# CITY OF ALBUQUERQUE

May 5, 2017

**RE: Paseo Marketplace  
Conceptual Grading Plan  
Revision Stamp Date: 5/3/17  
Hydrology File: D18D056**

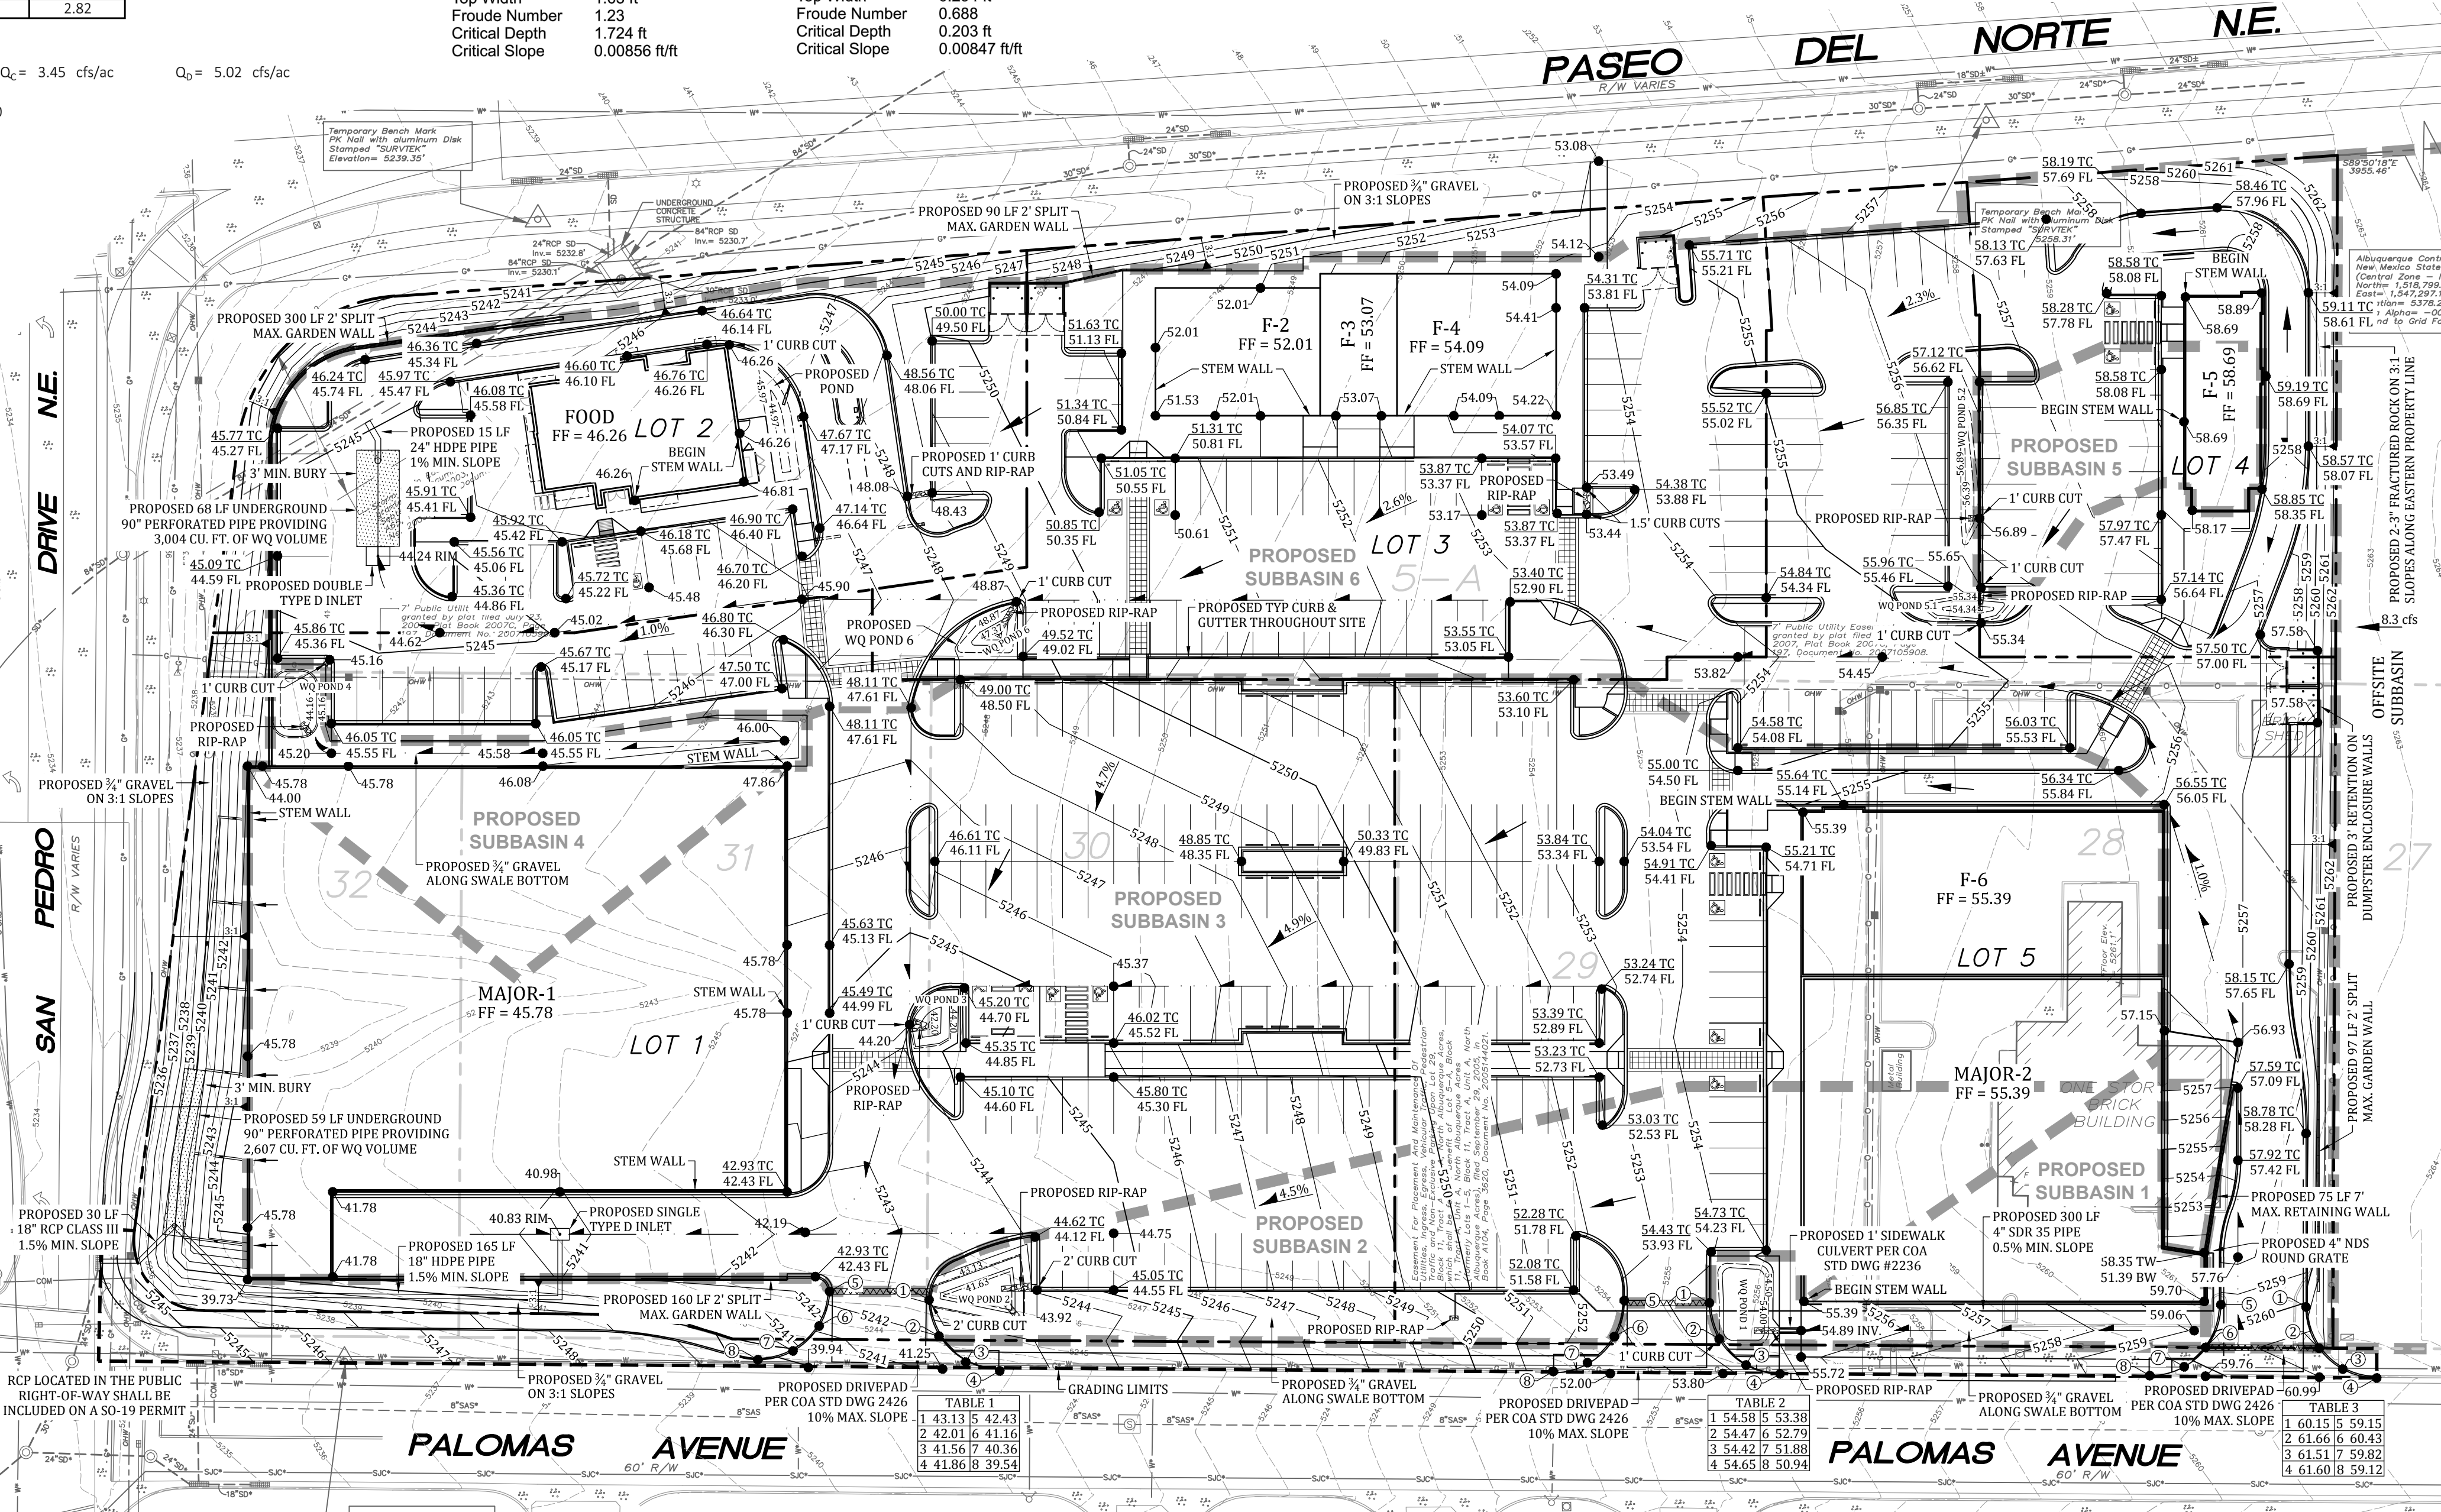
1. Under the Proposed Conditions – Subbasin 6, it states that the runoff will eventually reach the double Type A inlet. Since the inlets are not double Type A but double Type C as shown on the revised plans, please update.

2. Under the Proposed Conditions – Subbasin 6, the WQ volume required should be 3,132 CF as noted in the first flush volume calculations. Please update.

3. Included on the plans is The Oriffice & Weir Calculation for a double Type A inlet. Since the inlets are not double Type A but double Type C as shown on the revised plans, please update the Oriffice & Weir Calculations for a double Type C inlet.

4. Next to Building F-1, there is a proposed pond. Please provide the volume of this pond. Is this pond needed? I do not see this pond in the Proposed Conditions – Subbasin 6 paragraph. Please update if pond is needed.

5. It appears that only the note for the newly proposed Type C inlet is shown on the plan. Please show the newly proposed double Type C inlet. Also please label the rim and flowline elevations for the double Type C inlet.

6. The shown boundary of the Proposed Subbasin 4 was not updated with the revisions to Building F-1 and surrounding pavement. Please update boundary which will also effect Subasin 3 and 6 areas and supporting calculations. The calculations for all three Subbasins should be revised.

7. The proposed swale in Subbasin 4 does not match the revised proposed contours. Please update the swale or contours to reflect the proposed swale. Please also show the drainage arrows.

8. The one inch curb cut near WQ pond 4 did not get relocated in the revisions. The newly proposed Subbasin 6 drainage flow line to the double Type C inlets is very close to the one inch curb cut and drainage from Subbasin 6 will outfall through this to WQ pond 4. Please either relocate the one inch curb cut if it is still needed or remove it if it is no longer needed.

9. It appears that WQ pond 4 size and shape have changed with the revisions, however the water quality pond rating curve for the pond did not change. Please revise the calculations so that the required volume for Subbasin 4 is being handled in the revised WQ pond 4. If needed, than adjust WQ pond 4 so that it will hold the required volume.
